ExA Drafting queries on DCO (Doc Ref 3.01 Rev.0) as submitted

### Indicative Elevations & Section of Penstock Configuration (Revision 1)

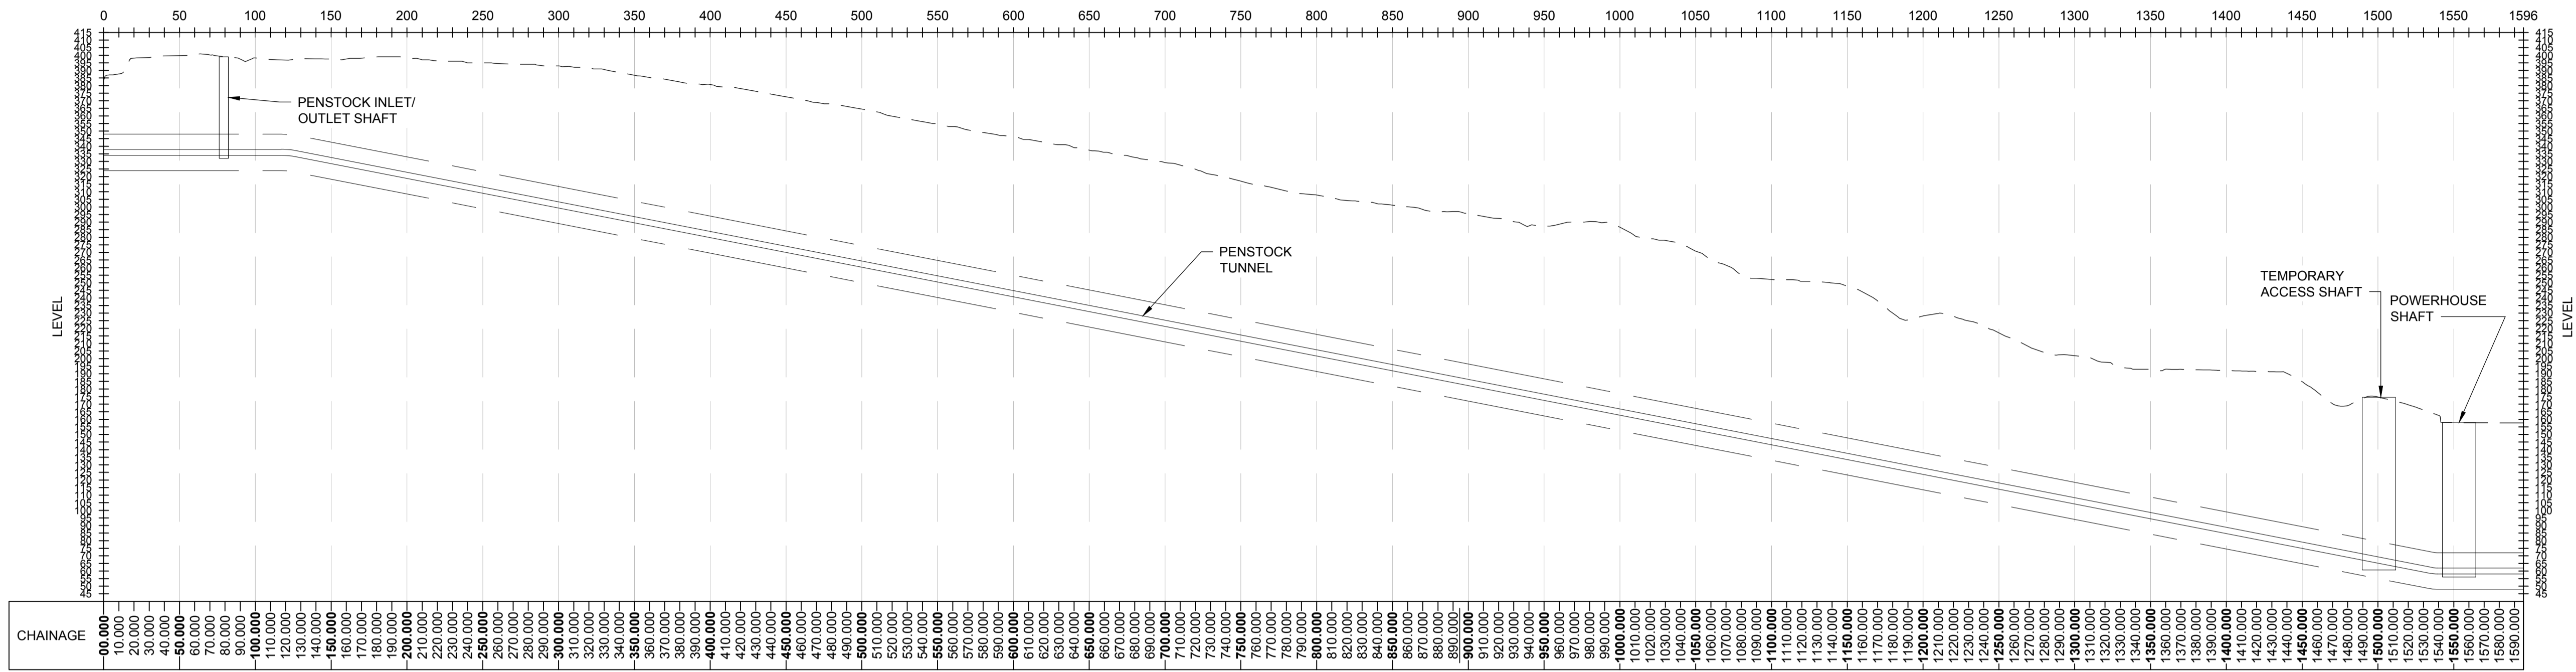
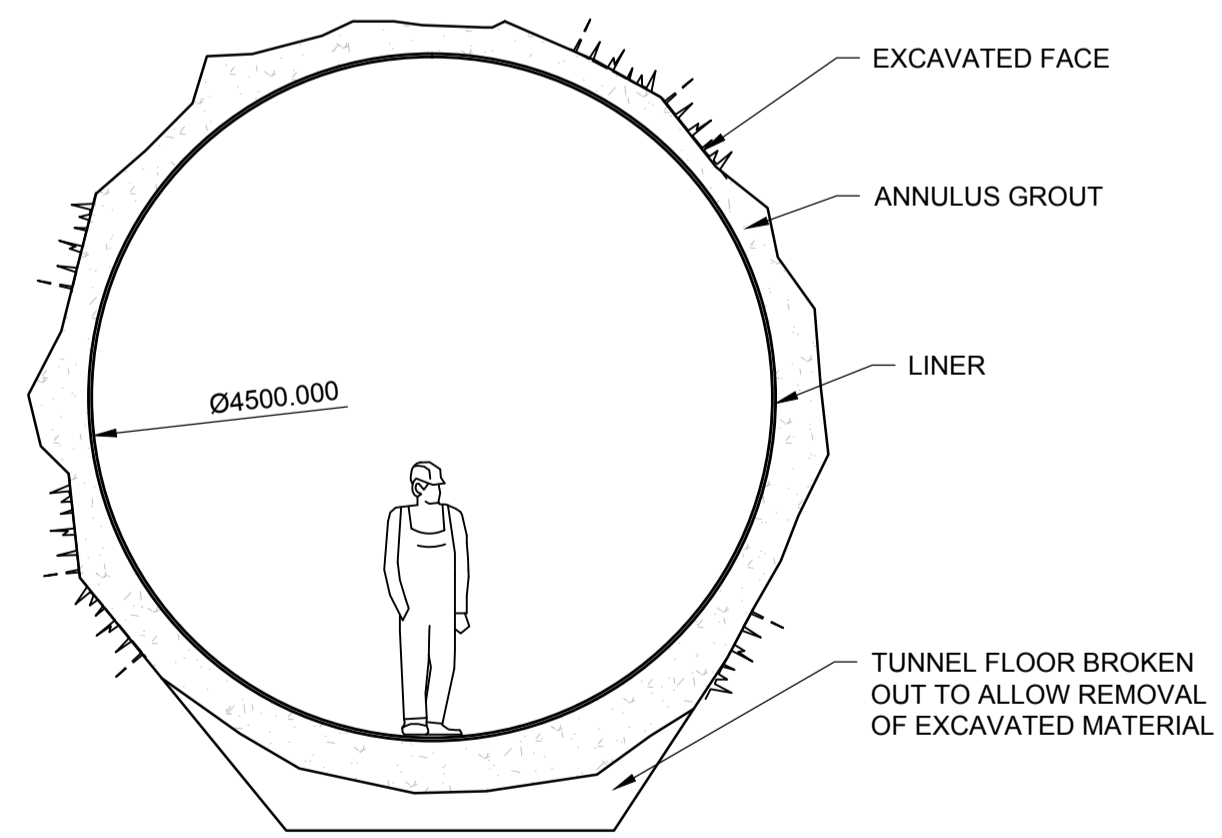
Question Number	Article/Requirement	Question Text
21	Article 6 – Power to deviate	<p>a) This is a very extensive power which (in addition to environmental effects) may impinge on mineral or other underground rights. Should LPA consent be required to deviation beyond limits assessed in the ES (or otherwise to be specified)? It is noted that the EM says that vertical deviation is allowed "subject to the maximum parameters set out in the requirements", but the parameters in R5 do not provide depth parameters.</p> <p>b) Can you identify where the environmental statement assesses vertical deviation, the baseline from which deviations will be judged under paragraph (2)?</p> <p>c) There should be a definition of "indicative engineering drawings and sections" in this Article or A2(1)?</p>
Snowdonia Pumped Hydro's Response

b) The limits of deviation on the power house shaft and penstock are related to geotechnical optimisation and geotechnical uncertainty. The objective of this provision is to allow adjustment to the turbine hall design and penstock alignment from the indicative drawings if geological conditions dictate. The precise shape of the turbine hall will be finally determined once the turbines have been selected. The maximum parameters set out a maximum volume for the turbine hall. The hall will require to be wide enough to allow the turbines to be inserted, operated and removed for maintenance, this places a minimum dimension on the size of the turbine hall and access shaft which in conjunction with the level constraint for pressure gives a maximum depth. The level of the turbine is determined by the required difference in pressure between the Lowest Operating Level (LOL) in Q6 and the turbine. The LOL is defined as that level above which the necessary storage (1.3Mm3) can be achieved and, in turn, is dependent on the assumed shape of the stabilised quarry. The penstock level may be amended depending on the geological conditions encountered en route, this may be horizontally or vertically with the end points fixed. The depth of the penstock is controlled by the topography (the need to connect Q1 to Q6), geological conditions and the need to align at the Q6 terminus with the turbine hall, it therefore cannot vary at this point by more than the change to the turbine hall depth.
